Markup Summary

Subject: Engineer
Page Label: [1] SNELL PLAT
Lock: Locked
Author: dsdgrimm
Date: 8/29/2018 10:01:45 AM
Color: ■

CHEYENNE MOUNTAIN STATE PARK EXPANSION - ROCK CREEK CANYON PARCEL
EXEMPTION PLAT
CITY OF COLORADO SPRINGS

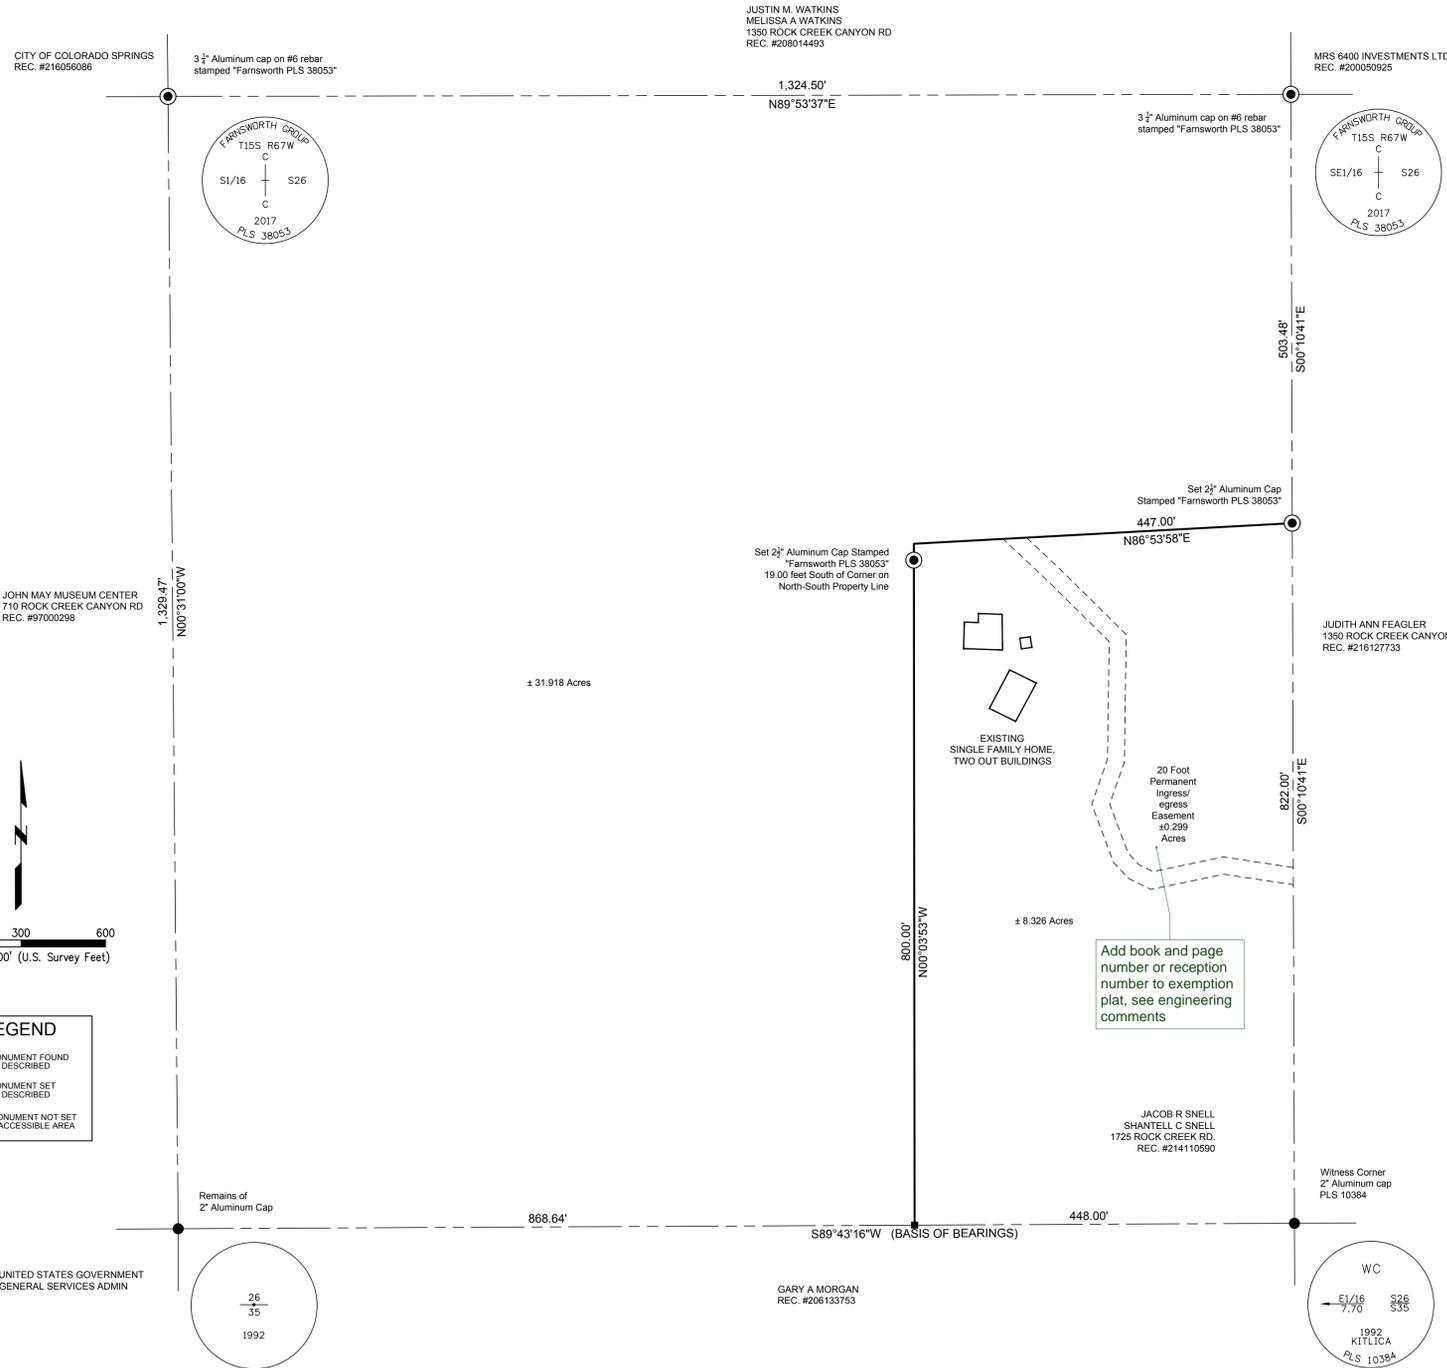
A driveway access waiver will need to be obtained. The permit application must be submitted to the front desk of Planning and Community Development.

Please reconsider naming to something more particular to the area the open space is located in, ie Cheyenne Mountain State Park Open Space or Snell Subdivision Exemption...etc

Provide documentation showing an ingress/egress easement to the nearest public road.

remove, not needed as you are not entering a PID.
